ENG-CDR20004-R4-CDs.pdf Markup Summary

Subject: Callout
Page Index: 1
Date: 5/10/2022 2:45:50 PM
Author: dsdrice
Color: ■
Layer:
Space:
Page Label: 1

POND W-3 OVERFLOW WEIR
SCALE: 1"=20'

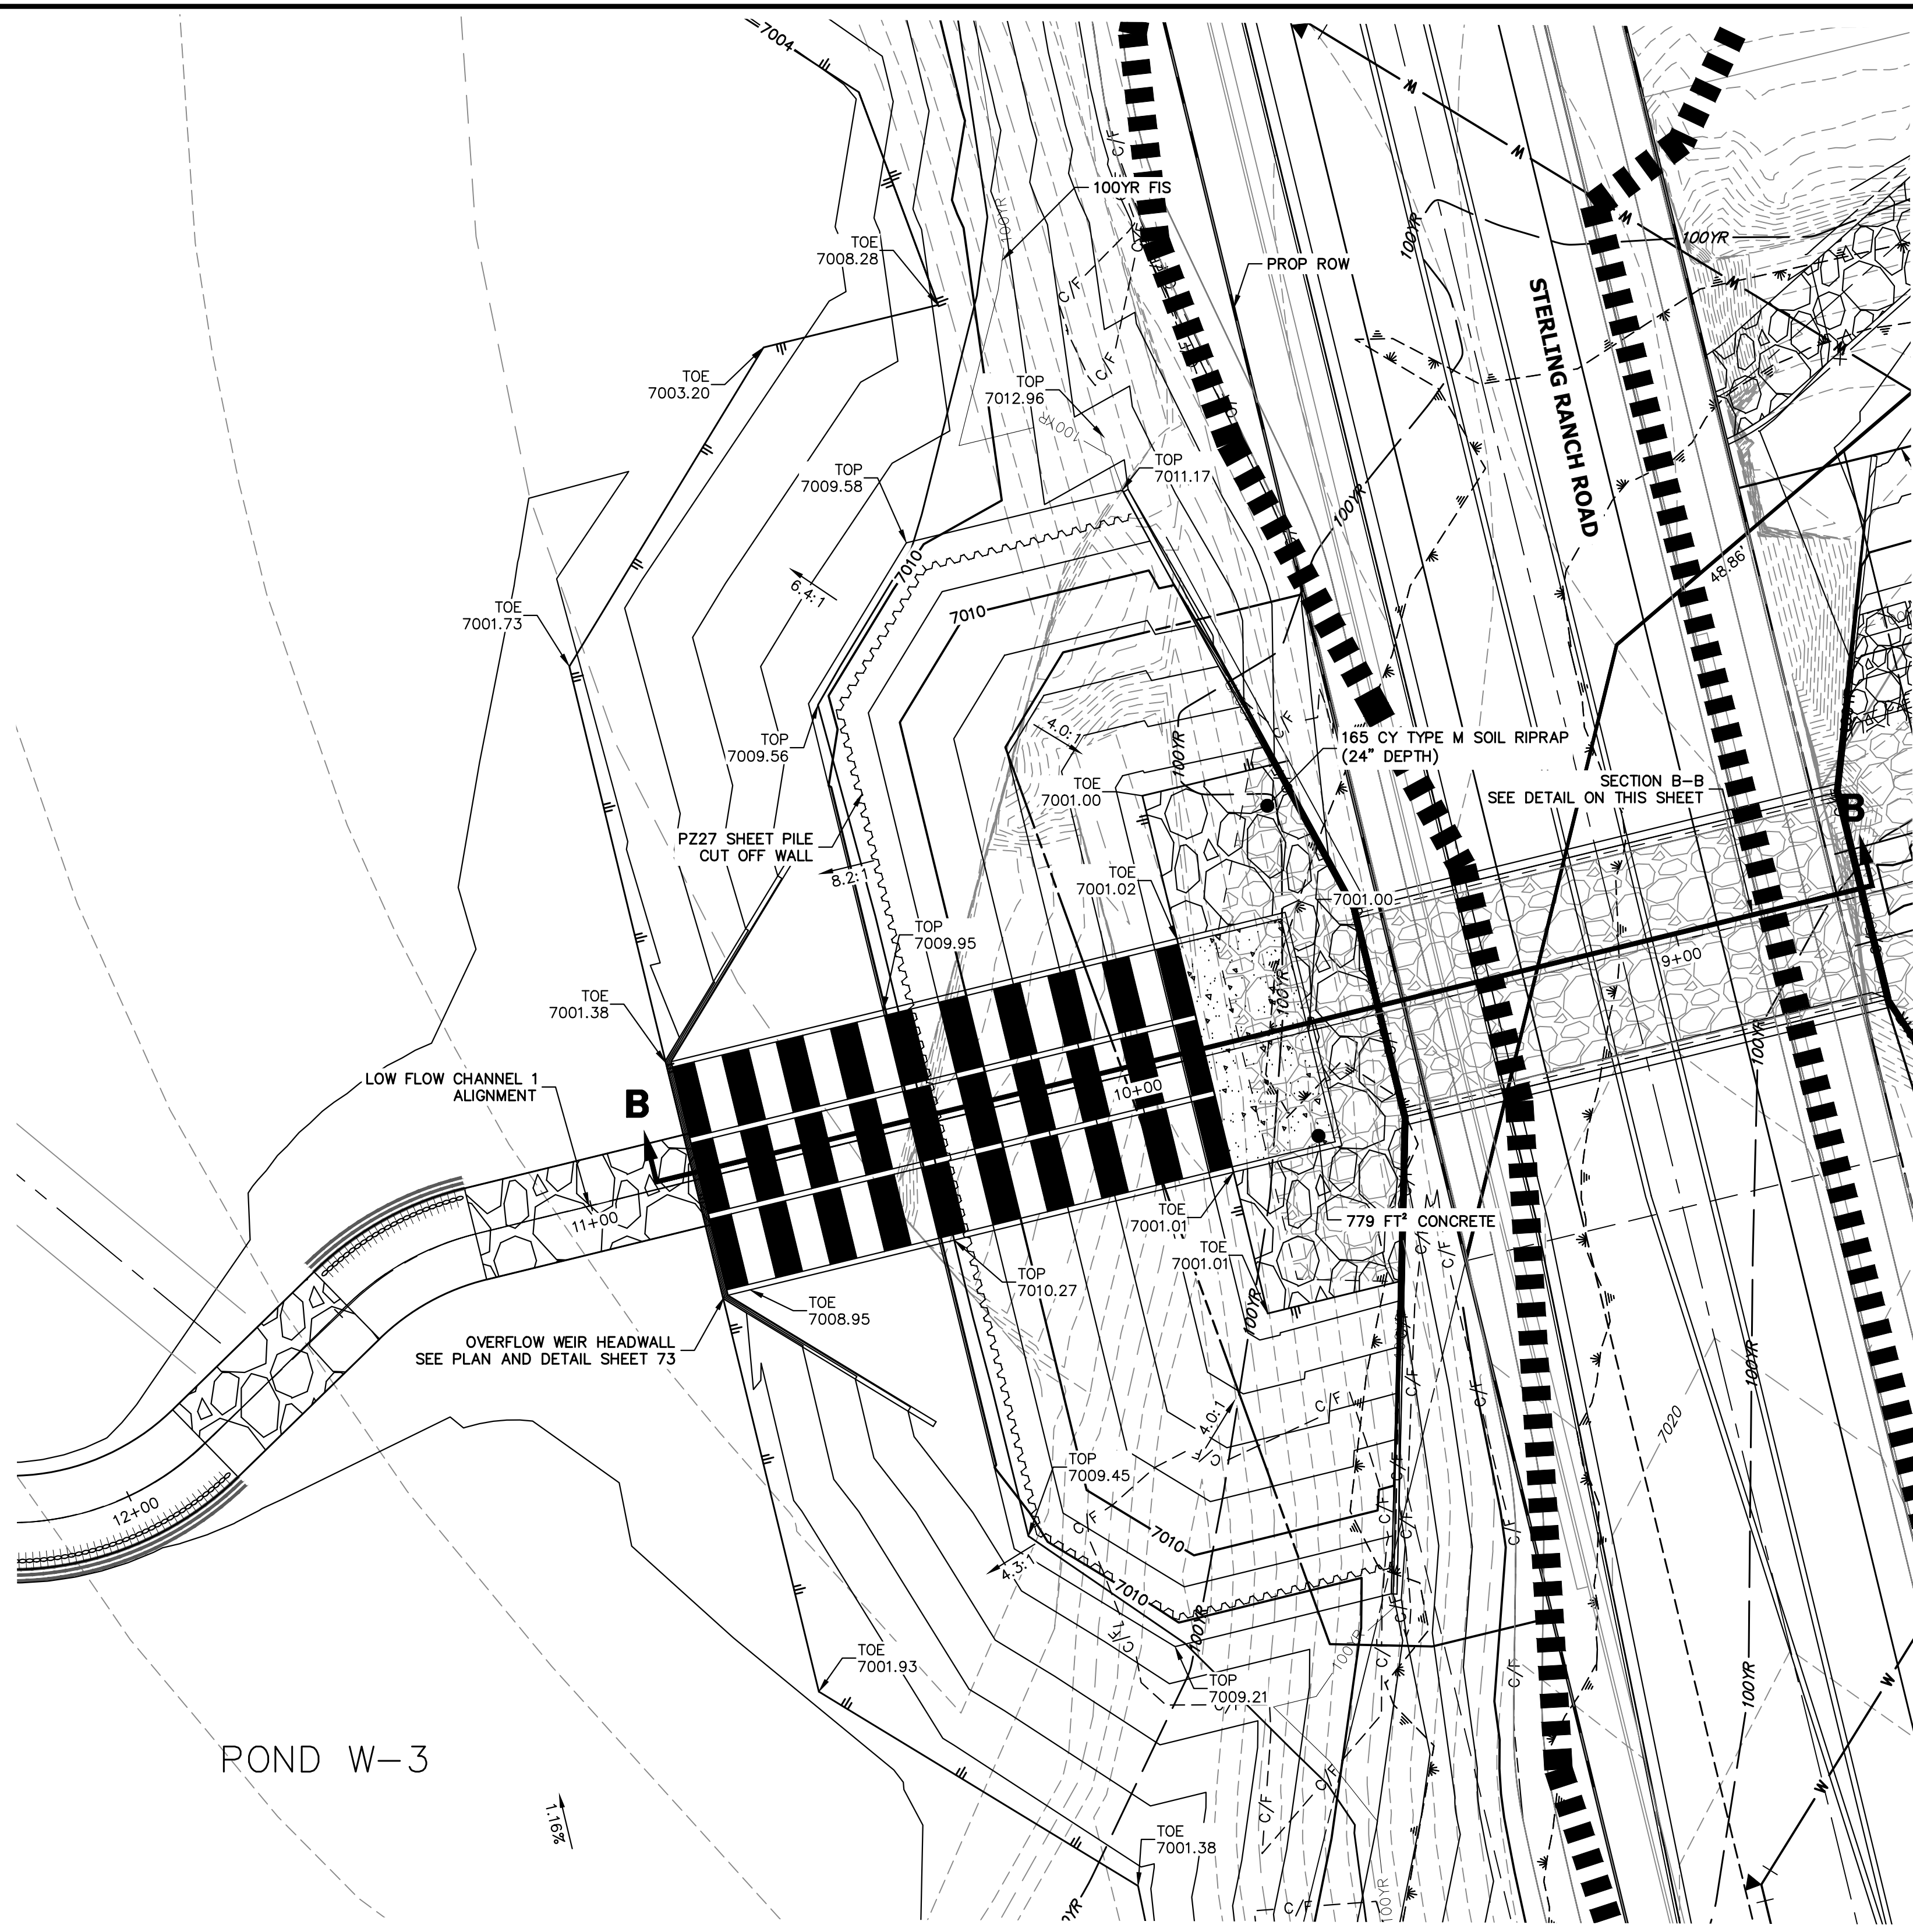
Show spillway riprap or provide a cross-section/profile in this direction on sheet 41
